Town & Country Planning Act 1990 (as amended)
Town and Country Planning (Development Management Procedure) (England) Order 2015
Application for approval of matters reserved by condition imposed under A/167/14/PL relating to
conditions 3, 4, 6, 10, 11, 12, 13, 14, 15, 18, 20, 21, 22 & 23 for schedule of materials, tree protection,
prevention of surface water drainage on highway, construction of roads, footways/casual parking
areas, Travel Plan, archaeological programme, ecological mitigation report, broadband speed, foul
water sewerage disposal, surface water drainage, SUDs system, refuse & recycling bins &
decentralised & renewable or low carbon energy source.
Former Pound Nursery Roundstone Lane, Angmering,

Condition Number 20

Arun District Council have decided to **REFUSE details reserved by condition for the following reasons:**

CLIENT	Barratt David Wilson Southampton				
PROJECT	Pound Nursery Roundstone Lane, Angmering				
TITLE	Site Layout Proposed Drainage Sheet 1 of 1				
DRAWN	A Davies	DATE	Dec 2014	PROJECT NO	22411
ENGINEER	G Waller	CHECKED		DWG NO	1221
SCALE	1:250 @ A1, 1:500 @ A3			REV	G

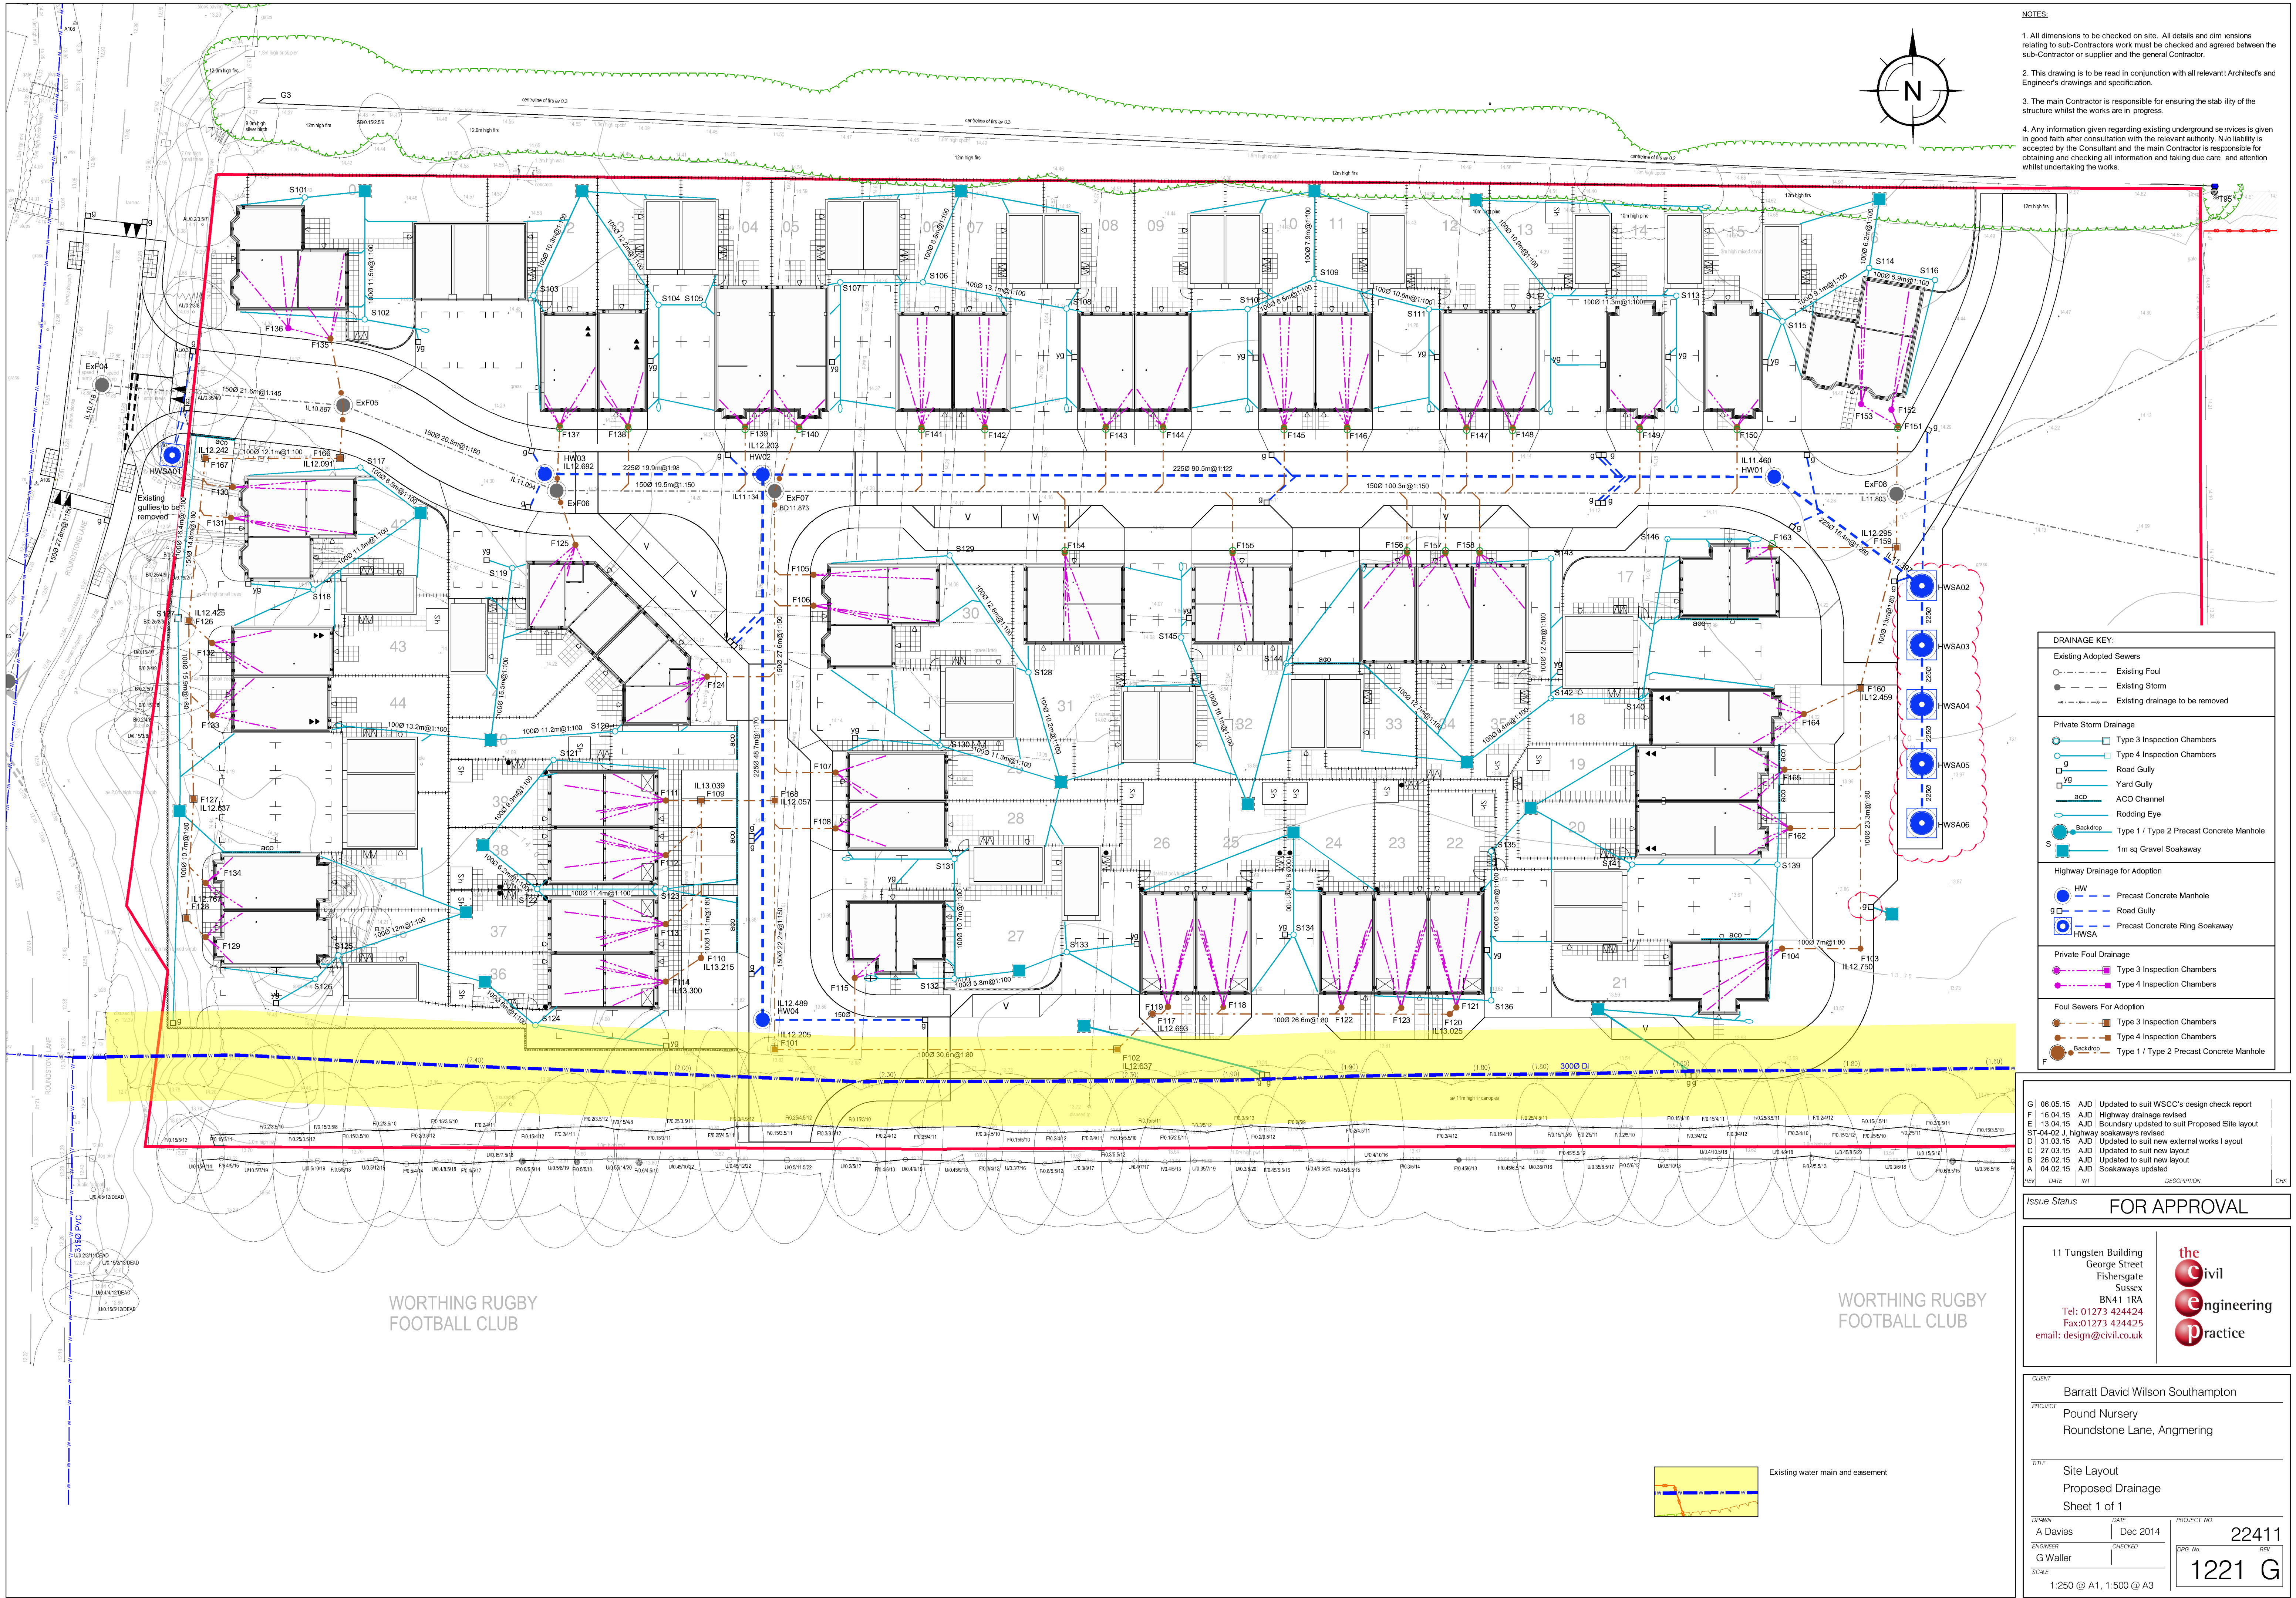
This condition cannot be discharged since detailed designs of the surface water system should be submitted and approved by the Local Planning Authority prior to development beginning. The drainage strategy should demonstrate that the surface water runoff generated up to and including the 100 year plus 30% for climate change critical storm will not exceed the runoff from the current site following the corresponding rainfall event. The scheme would need to be implemented in accordance with the approved plans. As the intention is to dispose to

infiltration, this should be shown to be suitable through an appropriate assessment carried out under BRE Digest 365 before the condition is discharged. Further information on this can be obtained from the West Sussex County Council Flood Risk Management Team.
